Consultation Response from Alan Smith,  
KC Waste Strategy( Refuse & Recycling)

2025/91185 building at, Back Chapel Lane, Moldgreen, Huddersfield, HD5 9BG

Demolition of redundant engineering building and erection of student accommodation block

Date Responded: 03/07/2025

**1** PROP. SITE PLAN  
 1 : 200

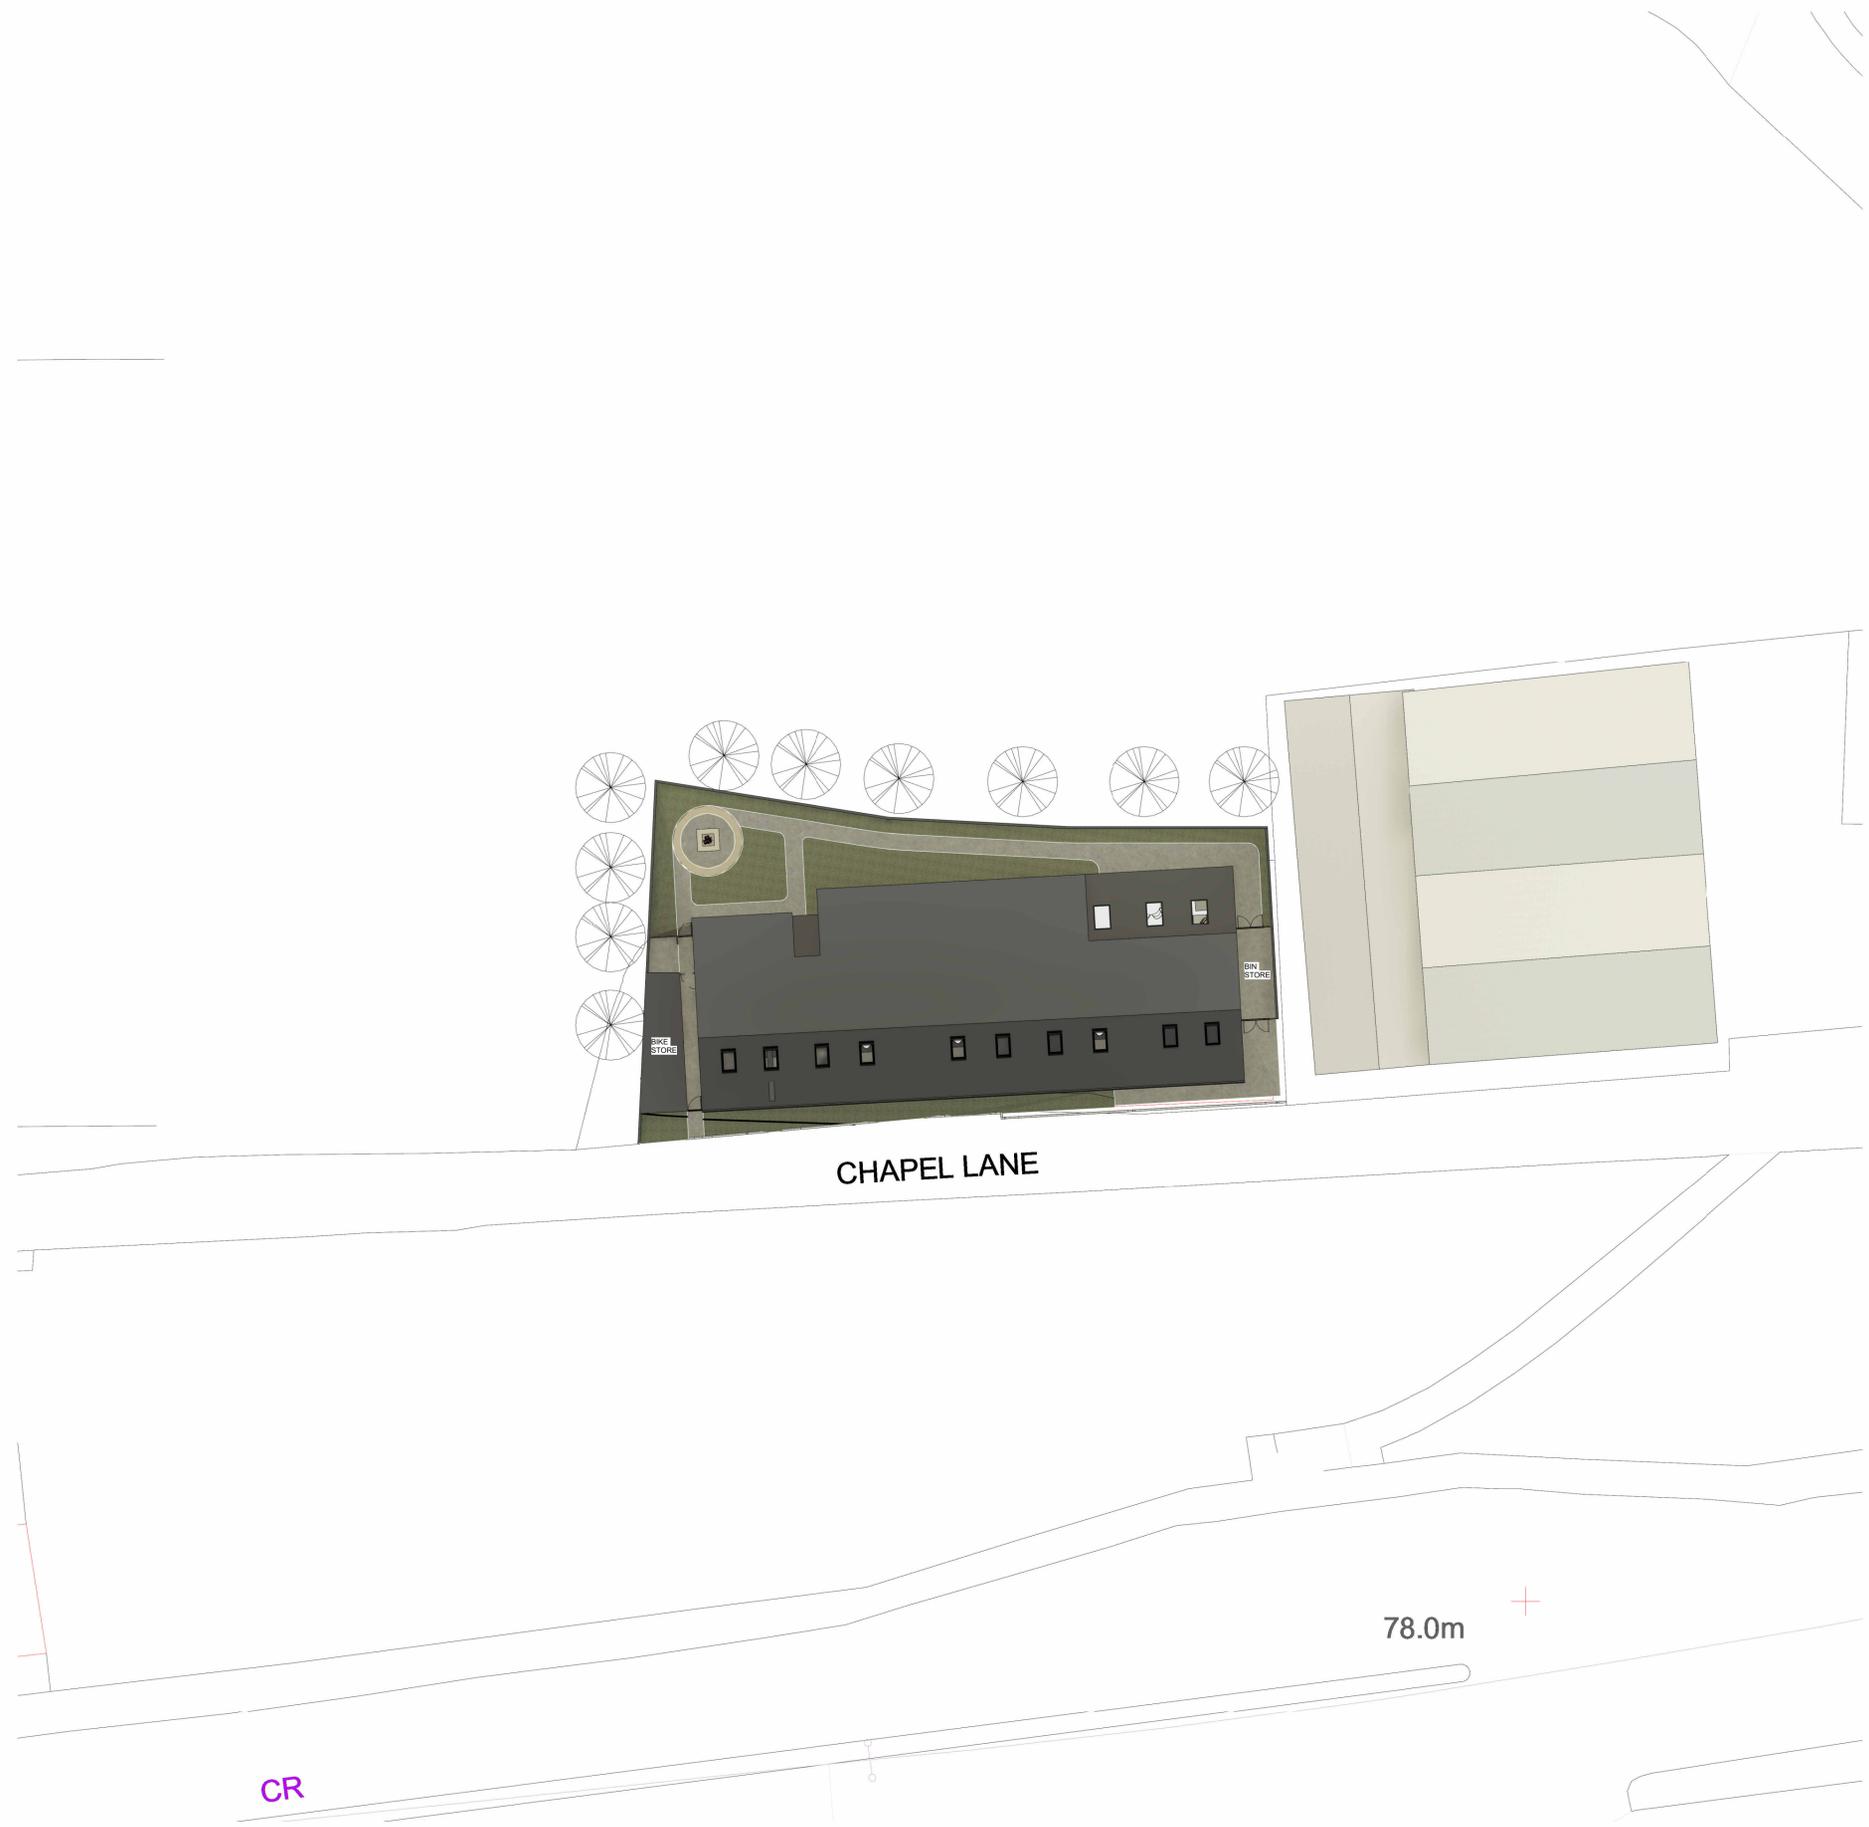
- The application is for the construction of 31 apartments. The plan shows the proposed wheeled bin store located at the East Side of the building off Chapel Lane. Waste storage capacity for 31 apartments should consist of 180ltr x 31 = 5,580ltrs. Assuming the use of 1,100ltr wheeled bins this equates to 5 containers each for both residual waste and recycling. So, **10 x 1,100ltr wheeled bins would be needed.**

- The communal waste storage area should be secured to prevent unauthorised use, rough sleeping, damage or theft.
- The bin store should be of suitable dimensions to accommodate the bins and constructed in compliance with the details specified in the design guide.

- Access from the bin store area to the Bin Collection Point (BCP) on Chapel Lane next to the highway should be constructed to withstand point loading and movement, impacts of larger bins over time, and to resist future rutting, pitting, cracking or other such surface degradation that would impair bin manoeuvring. **A drop kerb should be installed if there is a change of levels from the BCP to the highway.** Wheeled bins must not be permanently stored on the pavement or highway on Chapel Lane. There should be room to accommodate 5 x 1,100ltr at the BCP.

- A) Before development commences, further details to ensure suitable storage, and access for collection of wastes from the dwellings shall be submitted to and approved in writing by the Local Planning Authority. The approved details shall be provided before first occupation and shall be so retained thereafter.
- B) Before development commences, details of the management and maintenance of refuse storage areas and presentation of bins to the BCP on collection day, by a designated private management company shall be submitted to and approved by the Local Planning Authority. The approved details shall be provided before first occupation and shall be so retained thereafter.
